Project name	Hinckley National Rail Freight Interchange
File reference	TR050007
Status	Final
Author	The Planning Inspectorate
Date	24 October 2022
Meeting with	Tritax Symmetry (Hinckley) Limited
Venue	Microsoft Teams
Meeting objectives	Draft Document Feedback
Circulation	All attendees

Hinckley National Rail Freight Interchange – TR050007

Section 51 advice regarding draft application documents submitted by Tritax Symmetry (Hinckley) Limited

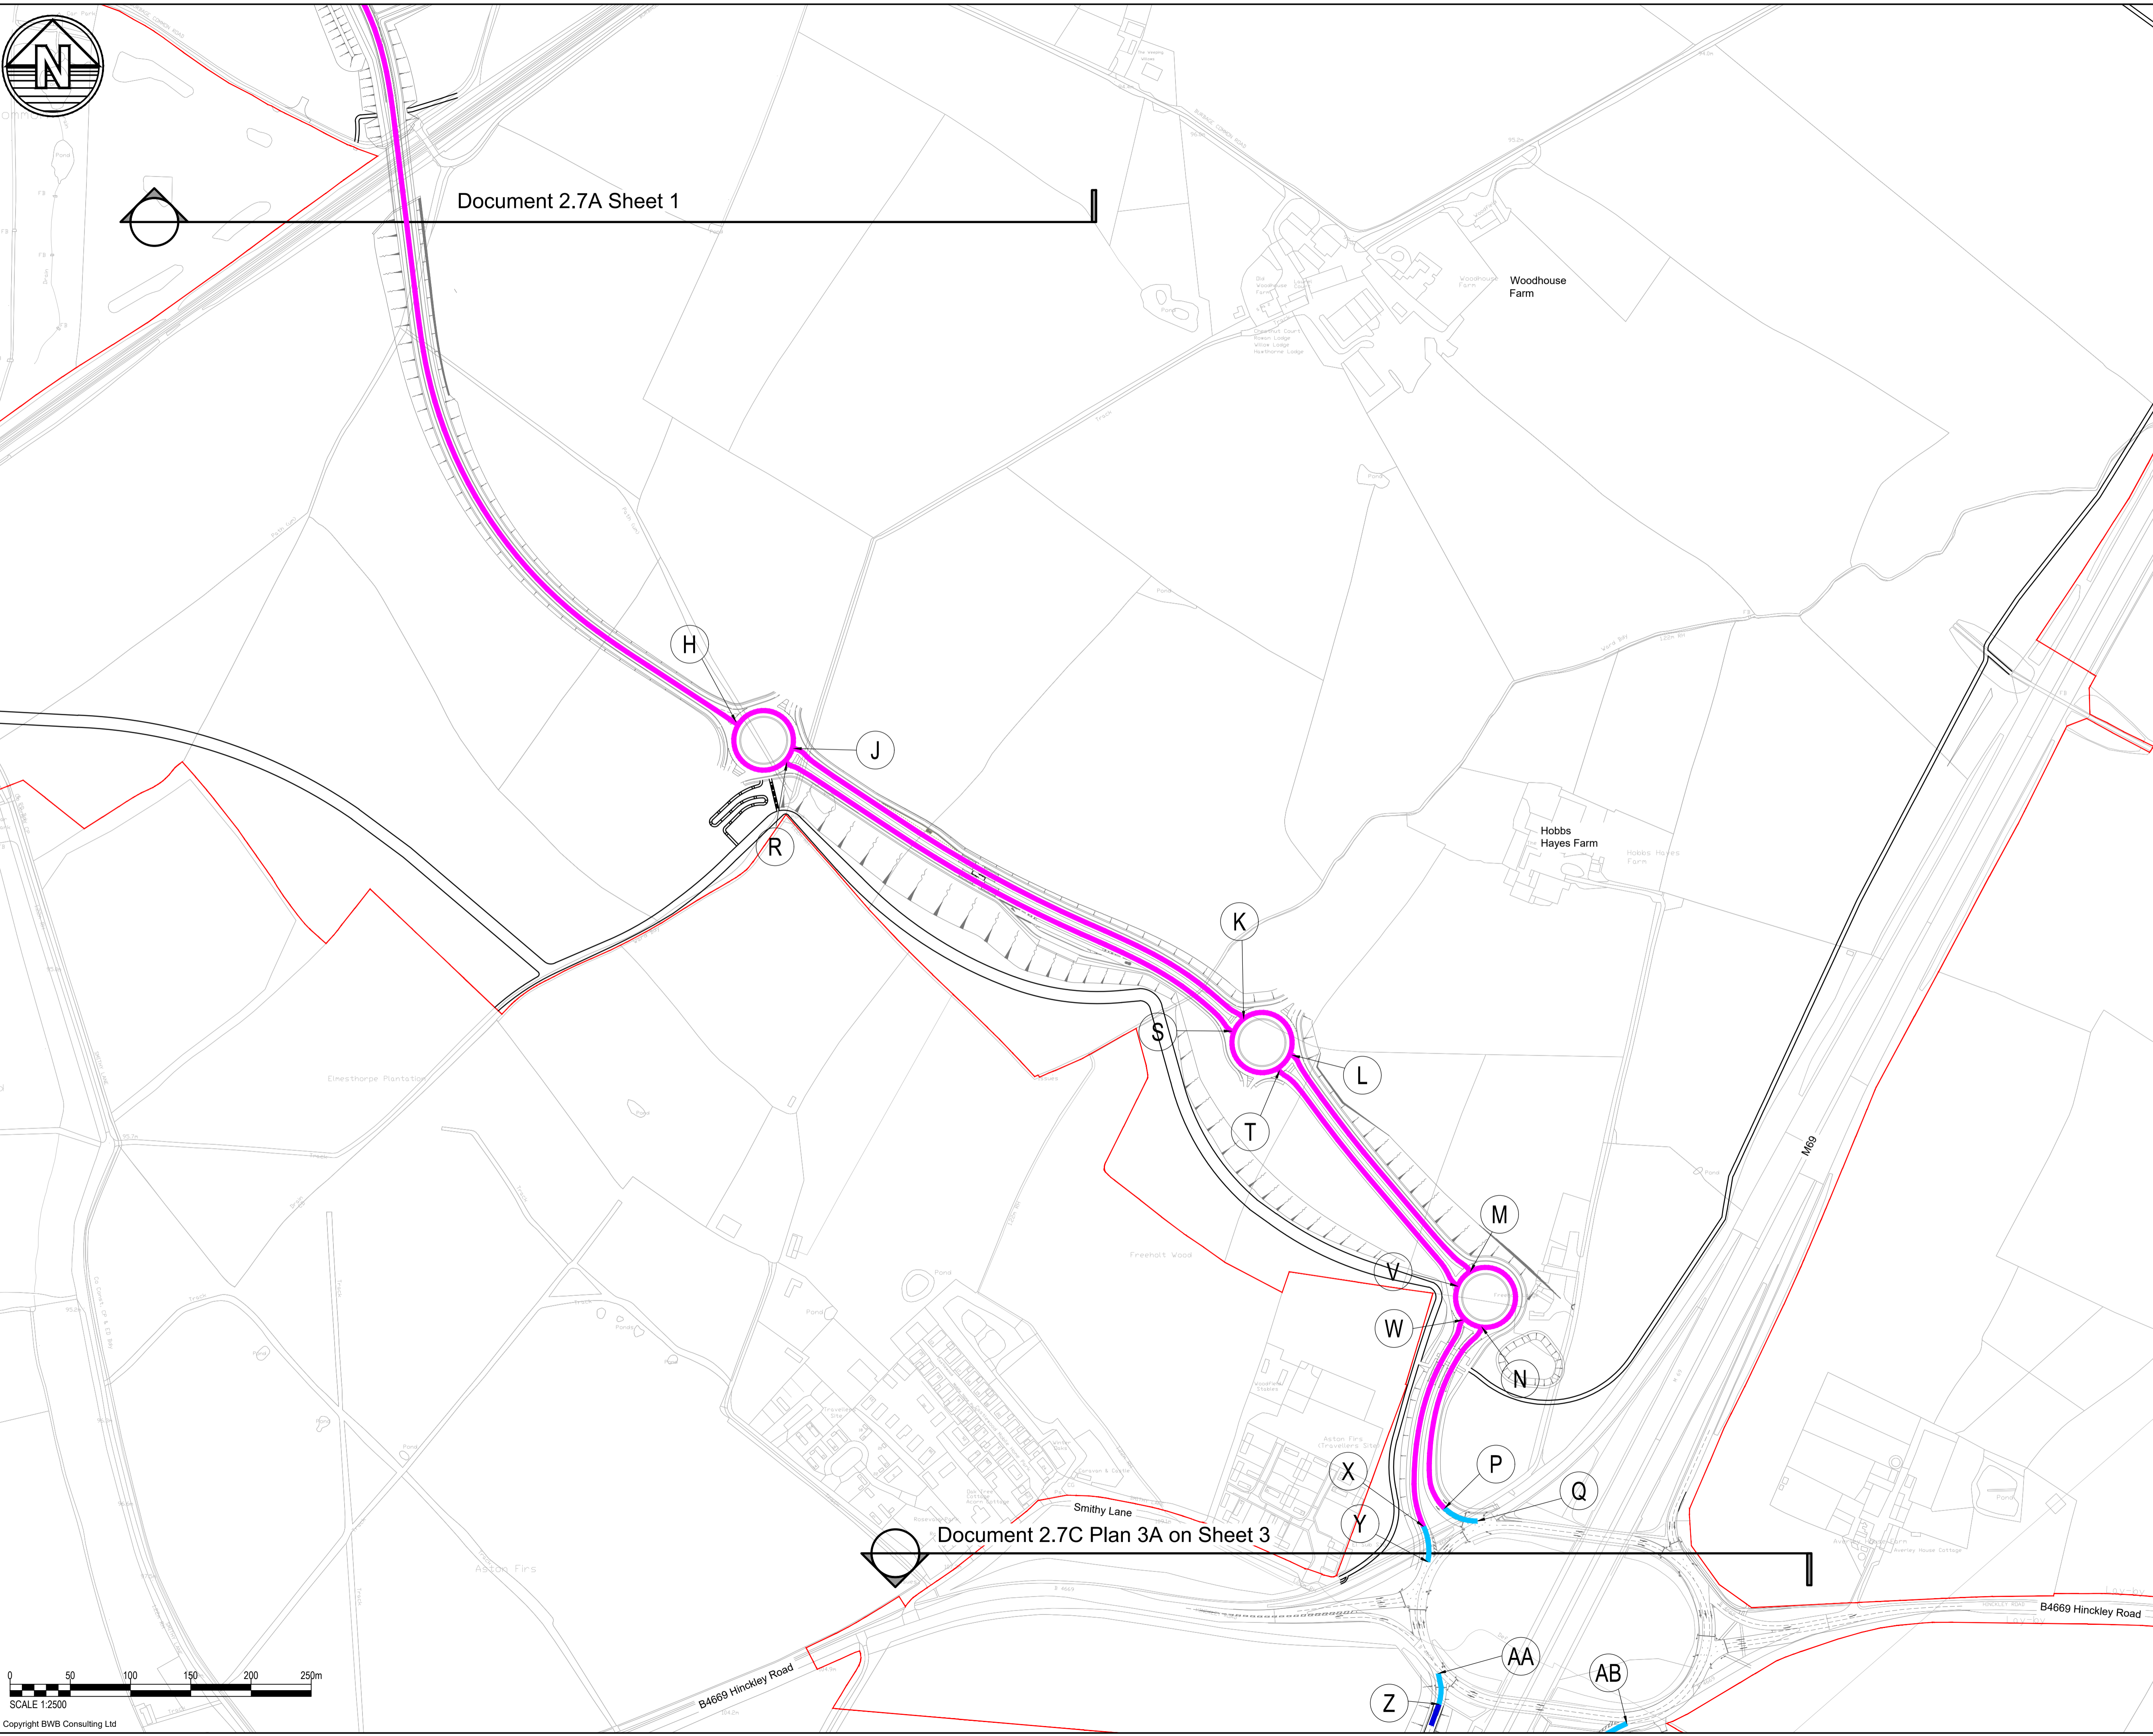
99.	HRF- BWBLSI-D2- DR- CH-00190	<p>SPEED LIMIT PLANS SHEET 2 OF 3 (Document 2.7B)</p> <p>The Plan clearly shows highways subject to ‘highways subject to 40 mph speed limit’, as described in Part 2 and ‘derestricted highways’, as described in Part 3 of Schedule 8 of the dDCO.</p> <p>It is noted that this plan appears to show items which are currently not present in Schedule 8 of the dDCO, specifically speed limits in relation to roundabouts K, L, S, T & M, N, V, W.</p>
